**From:** Charlotte Burrows on behalf of Planning.Responses  
**Sent:** 23 November 2011 11:18  
**To:** Planningecons  
**Subject:** FW: Planning Consultation on: AB/102/11/

**From:** Sue Simpson [mailto:sue.simpson@arundeltowncouncil.gov.uk]  
**Sent:** 22 November 2011 10:49  
**To:** Planning.Responses  
**Subject:** RE: Planning Consultation on: AB/102/11/

**APPLICATION** AB/102/11/  
**NO:**

**Description of Works:** Ground floor extension to rear of property and erection of amenity workshop to rear of garden

Drawing Title  
General arrangement drawing 2

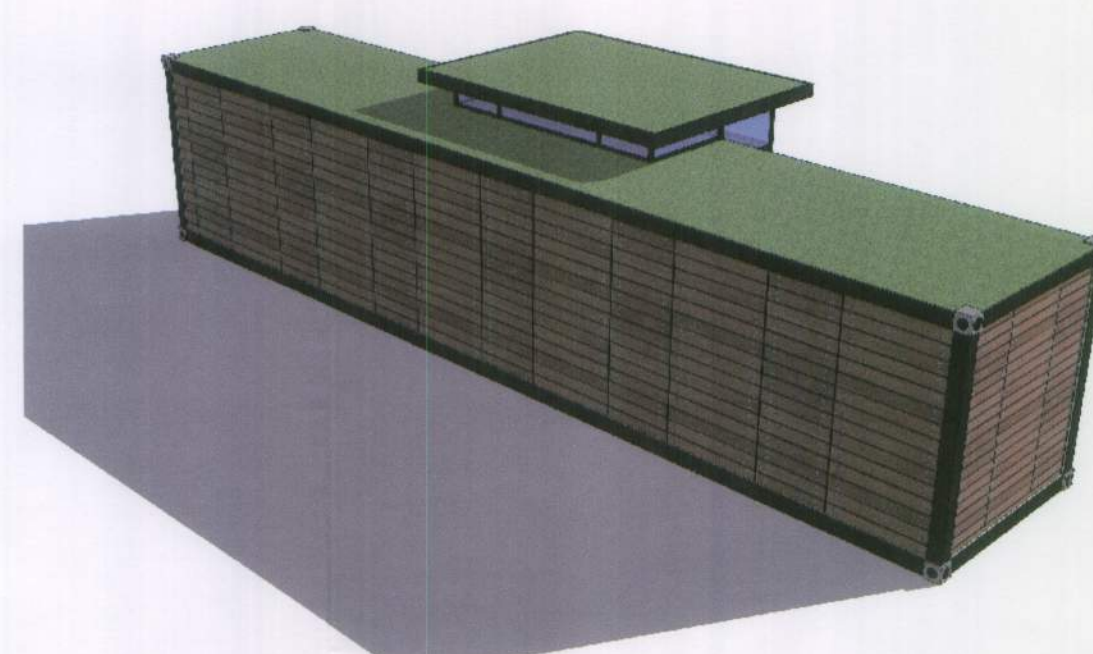
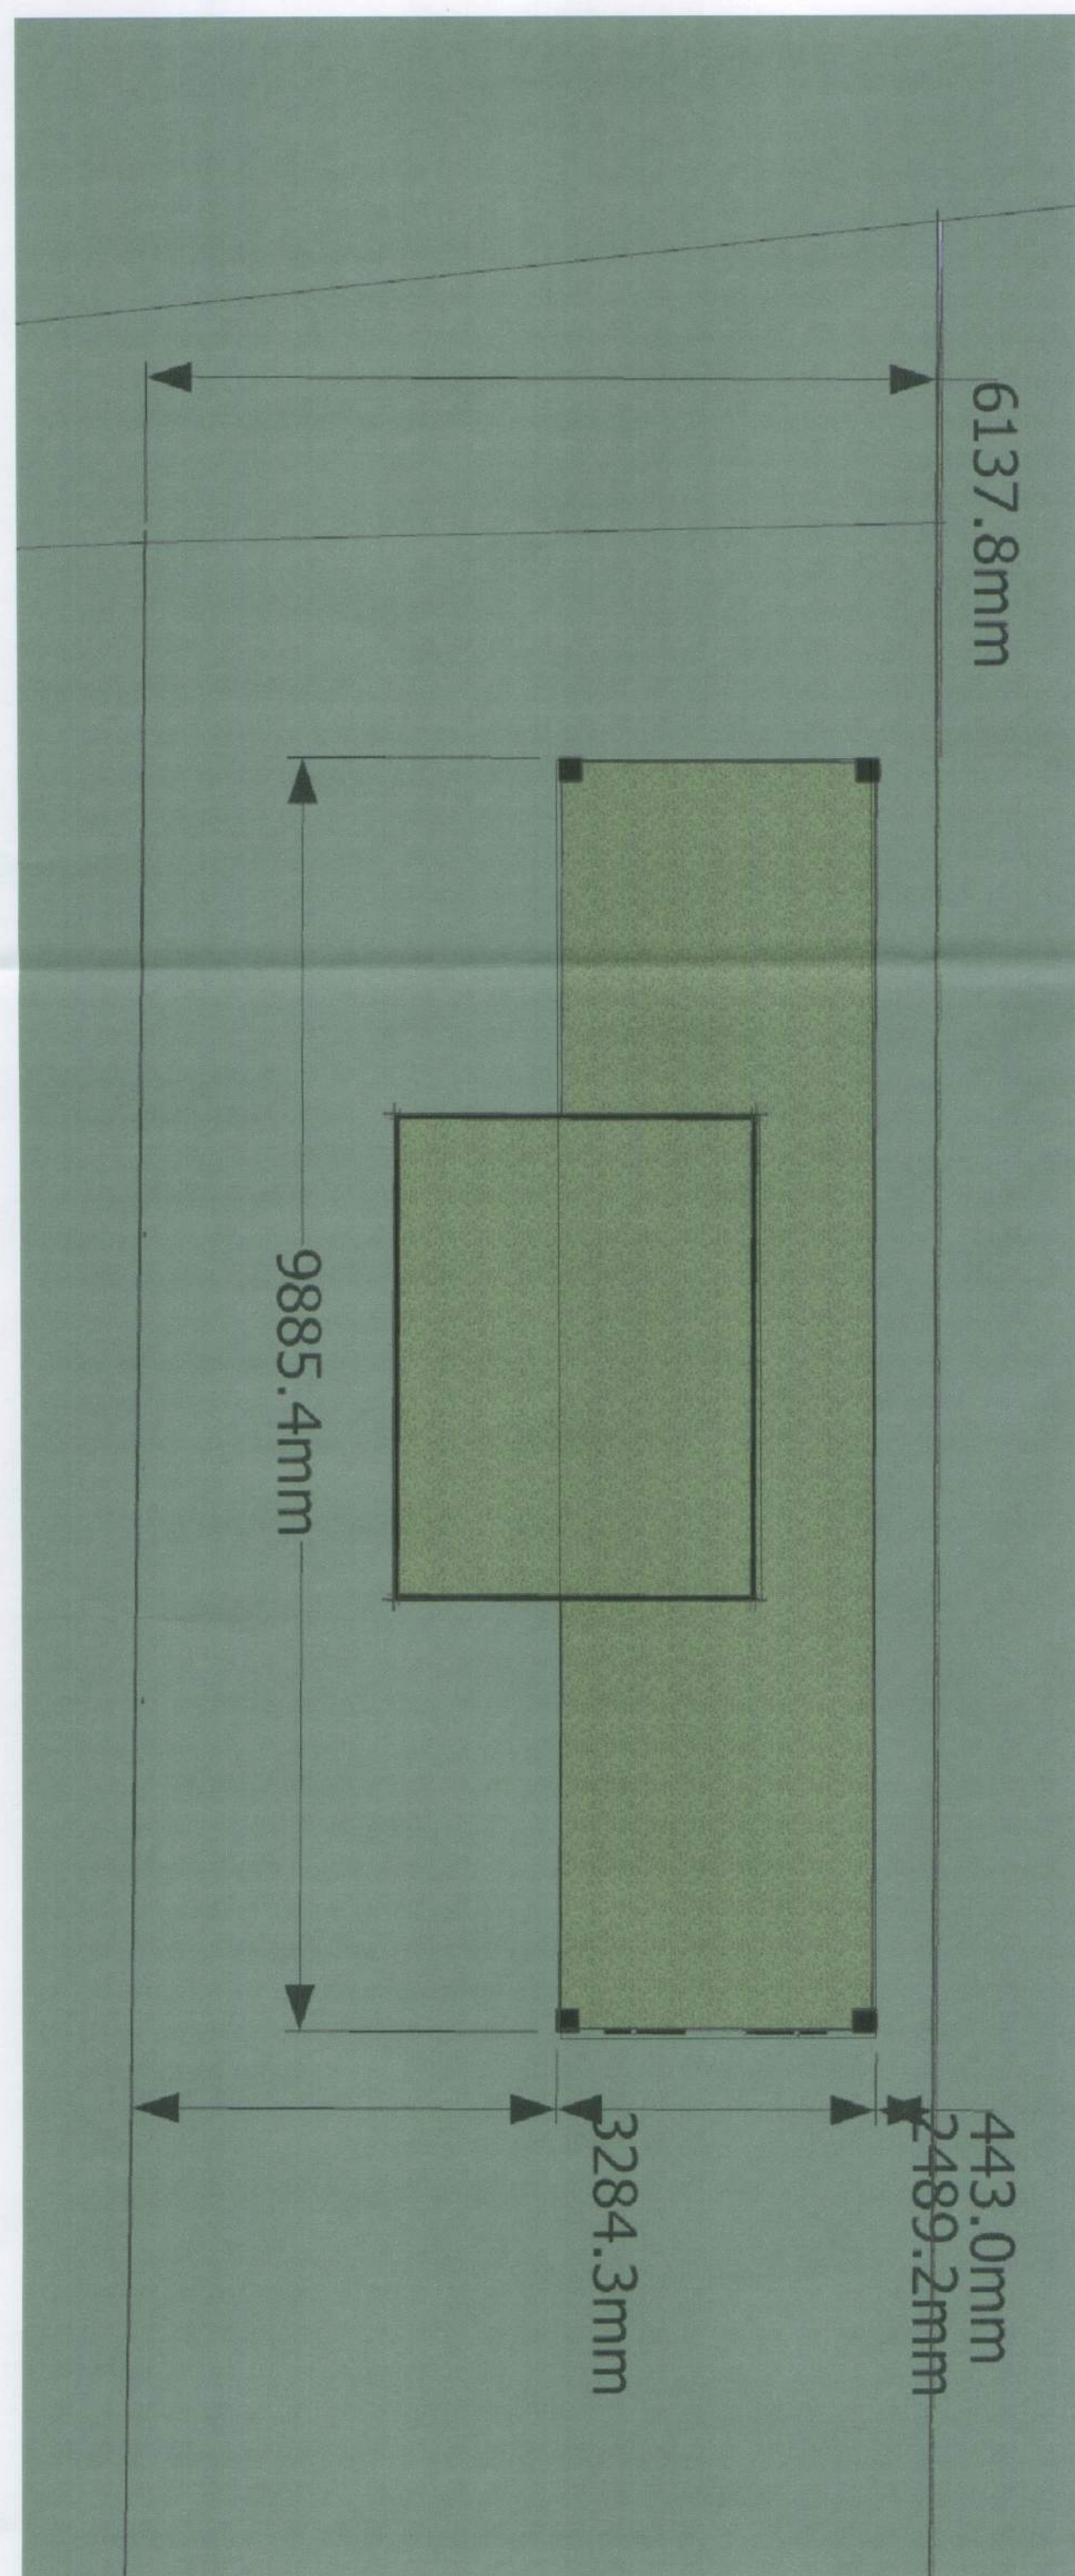
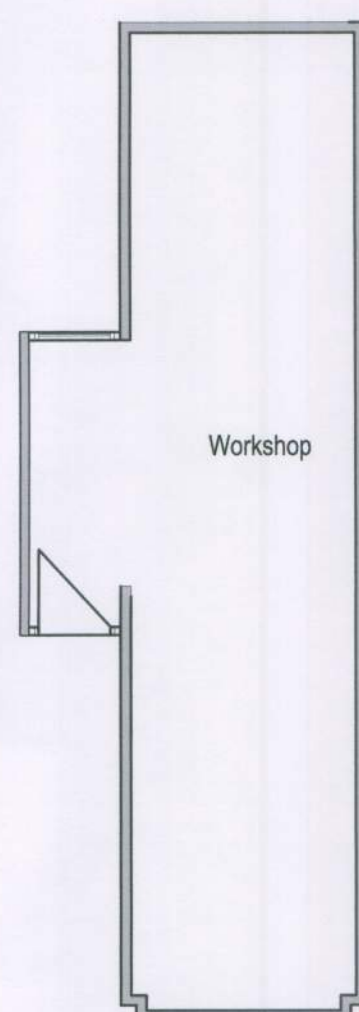
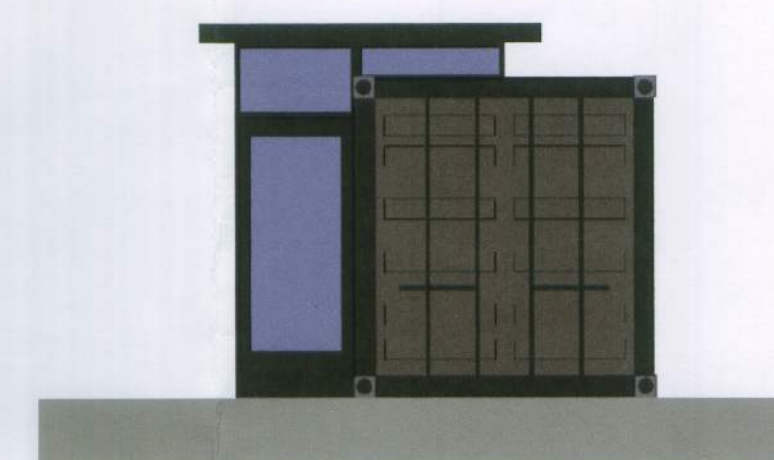
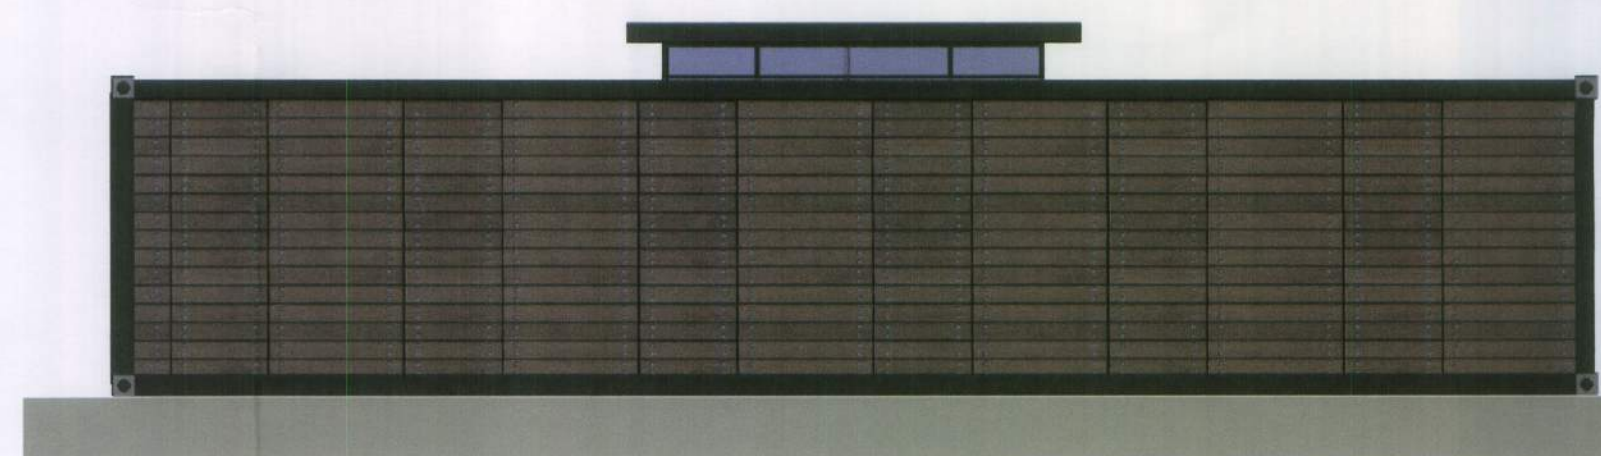
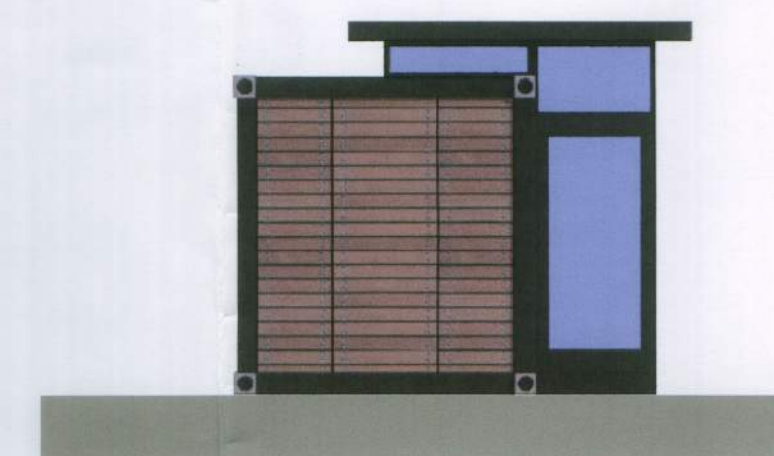
**The Committee had no objection to the proposed ground floor extension but objected to the erection of the amenity workshop (described as a different use on the application drawings) on the grounds that it was unduly large in this garden location and would appear unsympathetic, obtrusive and out of character and appearance with the area when viewed from the river bank.**
